18th March 2026

Town & Country Planning Act 1990 (as amended)
Town & Country Planning (Development Management Procedure) (England) Order 2015

Application No: R/31/26/HH
Site Address: 15 Evelyn Avenue Rustington BN16 2EJ
Description of works: Single storey front porch and rear extension to replace the existing conservatory, proposed hip to gable extensions, a rear dormer, roof lights and side windows with obscure glass.

Rev.	Notes	Date
 NAT DESIGN ARCHITECTURAL SERVICES M: 07599199759 E: info@nat-design.co.uk www.nat-design.co.uk		
Project		
15 Evelyn Avenue, Rustington, BN16 2EJ		
Drawing		
Proposed Site & Roof Plans		
Drawn By NSE		Scale as shown
Date Feb 2026		Revision
Drawing No. 2027 -DPA - 02

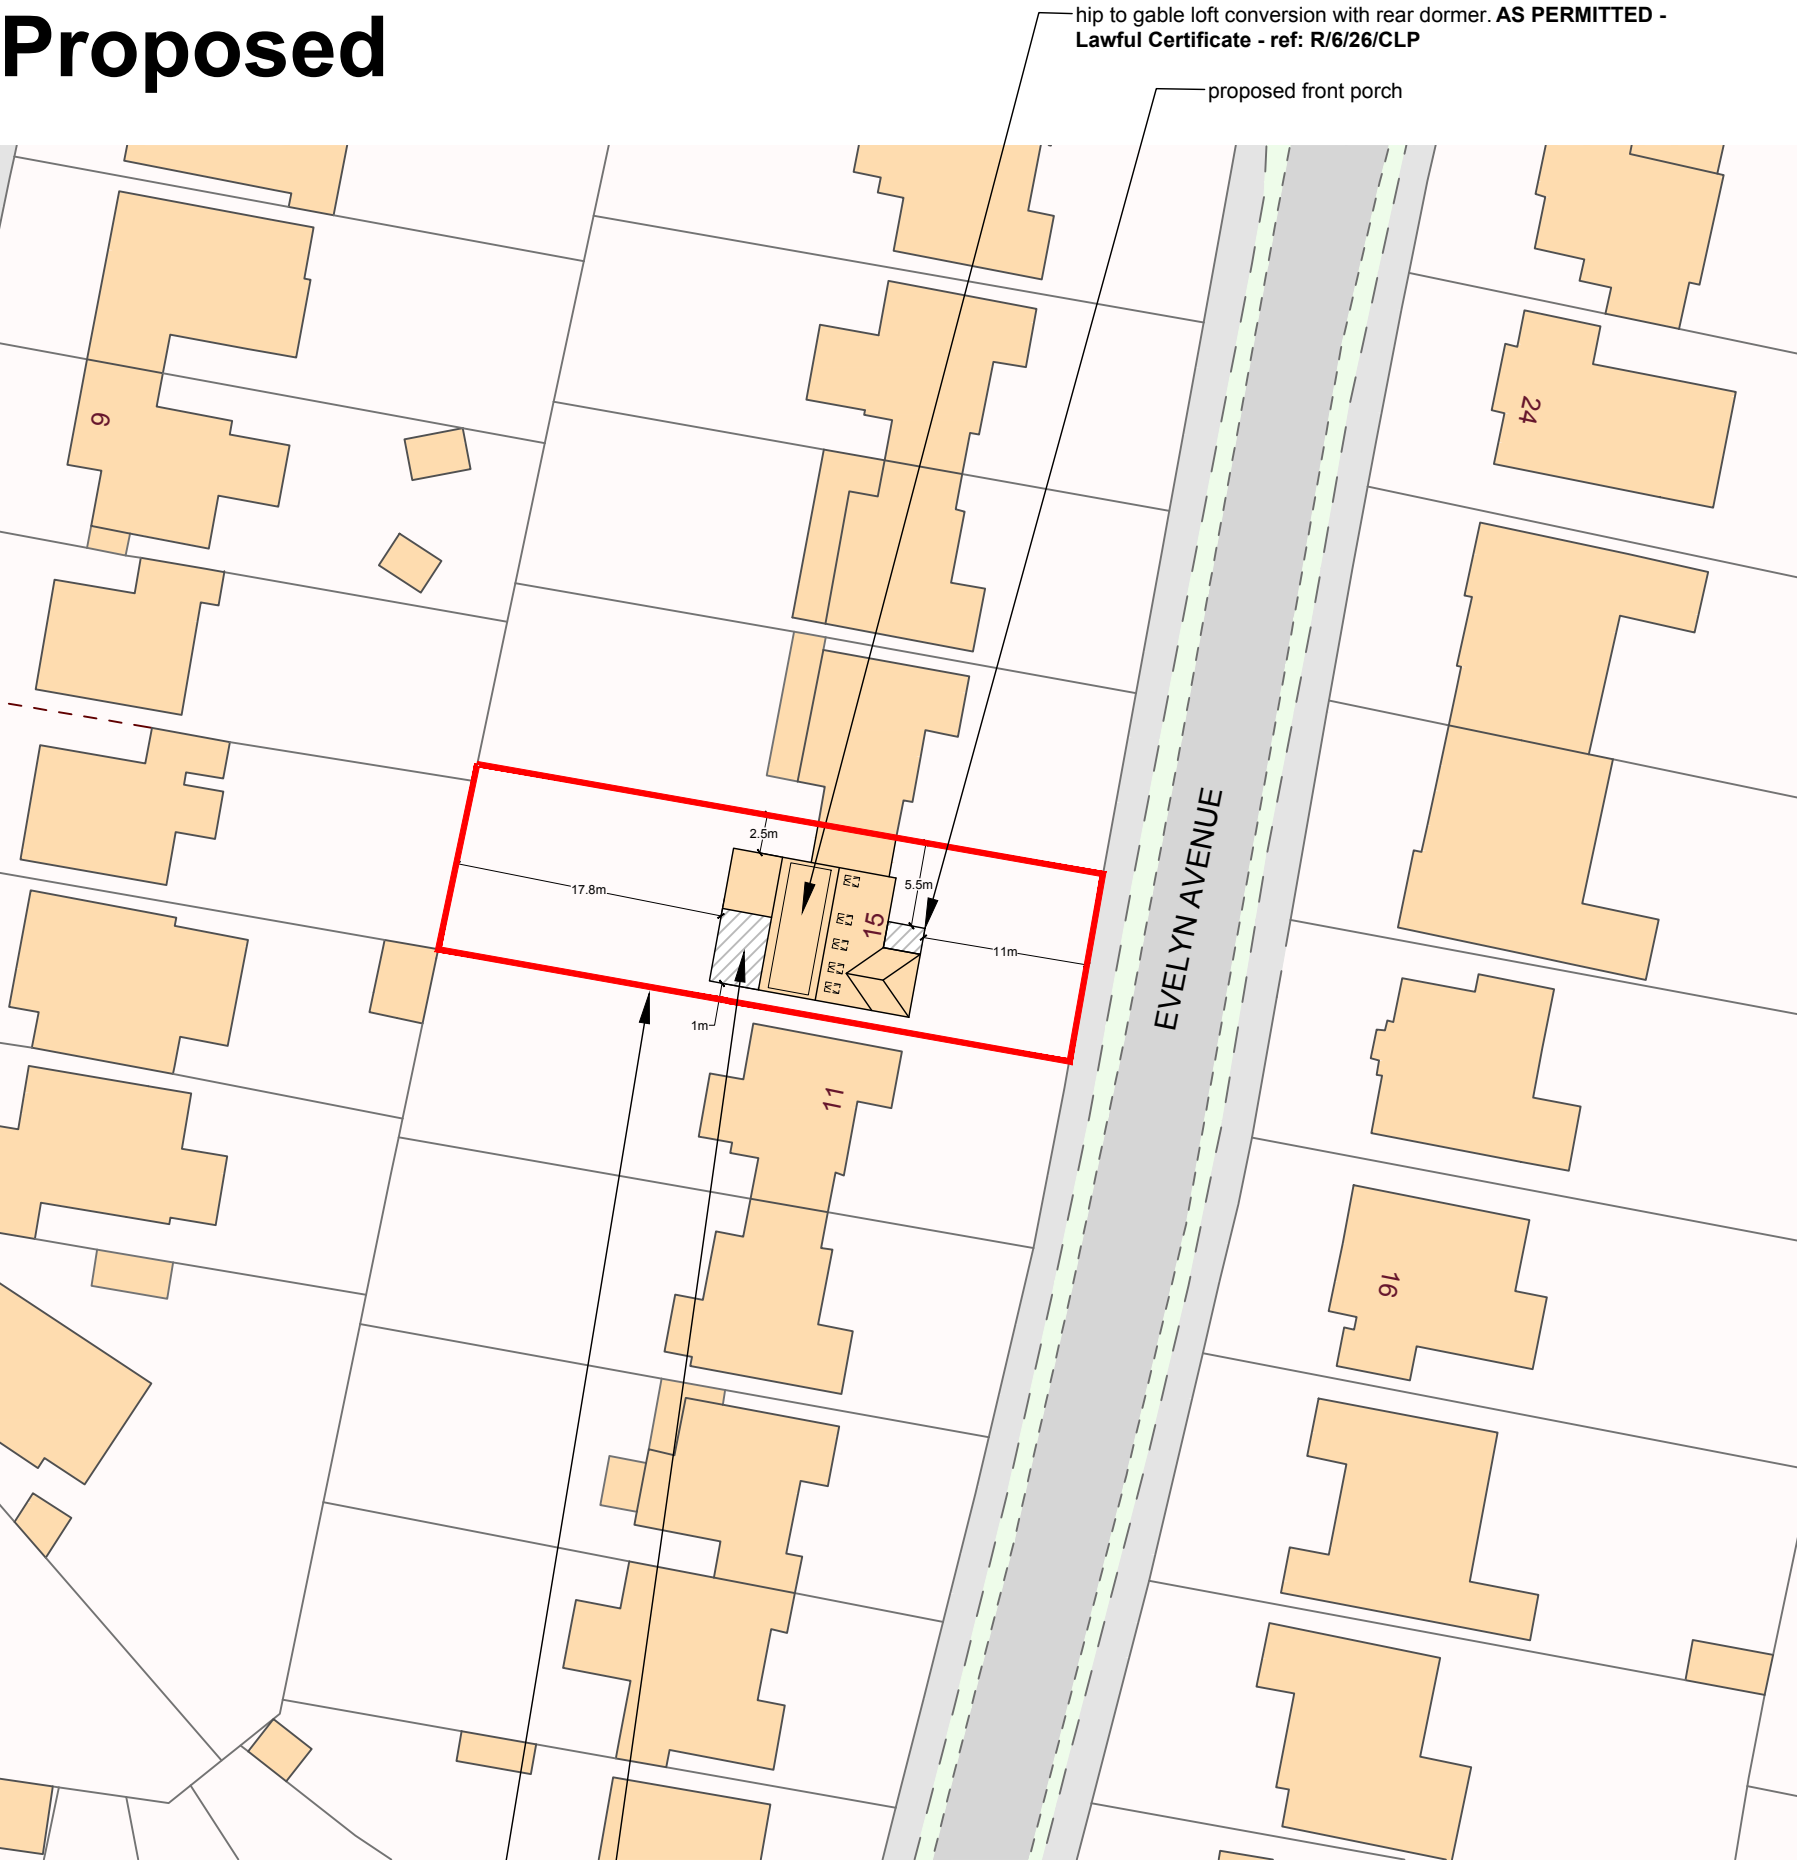
(i) The proposal for hip to gable extensions both sides and an extensive full property width rear dormer, by reason of its size, mass and design would present an overbearing and unsympathetic appearance for the occupiers of the neighbouring properties, and would result in a serious loss of light and privacy, particularly for the occupiers of No. 11 Evelyn Avenue, which is only two metres in distance away. This would, most certainly, adversely affect their visual amenities and quiet enjoyment to an unacceptable degree

Rev	Notes	Date
 M: 07599199759 E: info@nat-design.co.uk www.nat-design.co.uk		
Project:		
15 Evelyn Avenue Rustington BN16 2EJ		
Drawing:		
Proposed Elevations		
Drawn by NSE		Scale as shown
Date Feb 2026		Revision
Drawing		
2027 - DPA - 06

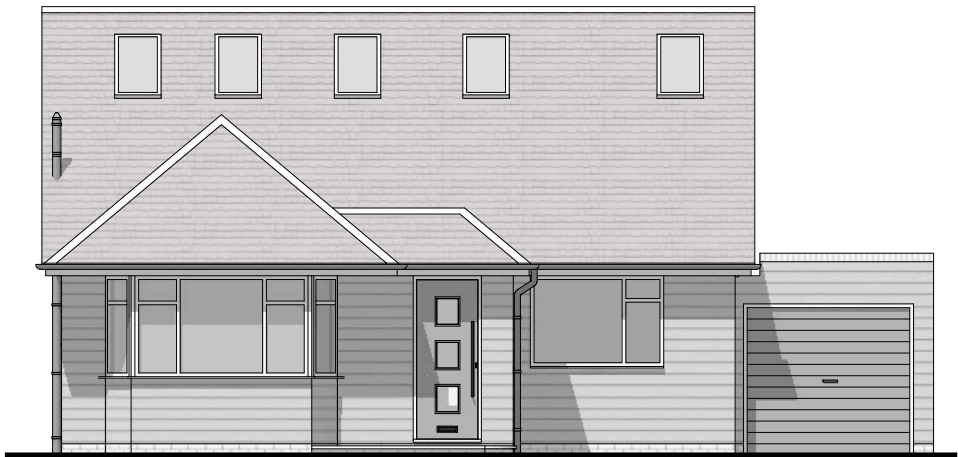
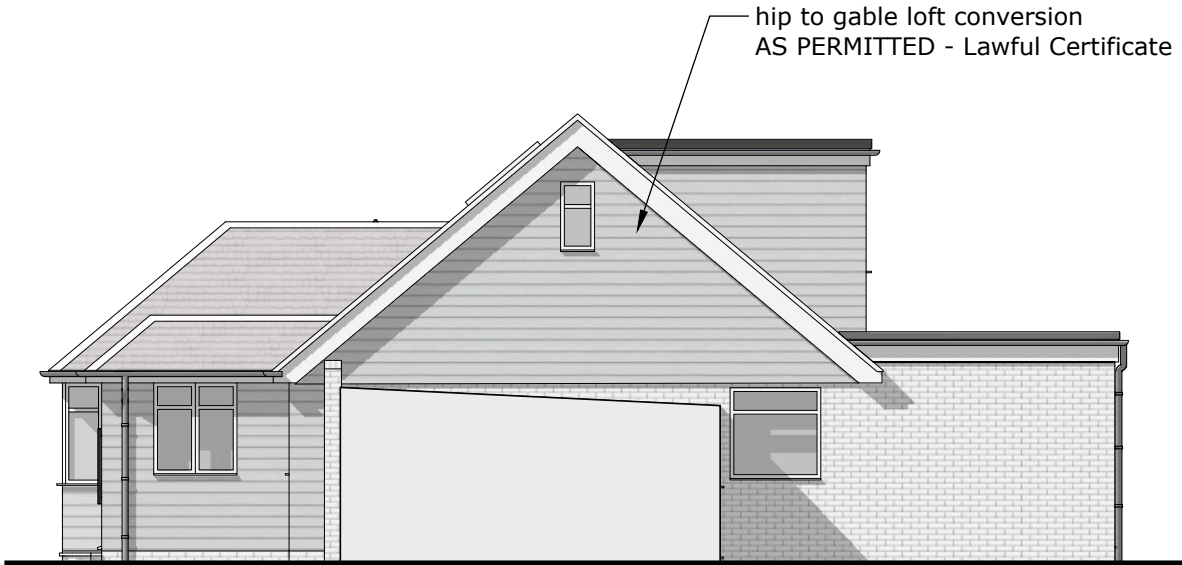
(iii) The accumulation of the hip to gable extensions both sides and the over-sized rear dormer render the proposal to be totally out of keeping with the street scene and would most certainly be prejudicial to the established character, amenities and environment of the locality

(iv) The proposal, in respect of the cladding to the front of the property, would adversely affect the character and appearance of the street scene, where all other nearby properties have brick frontages. This would present a fundamental change aesthetically.
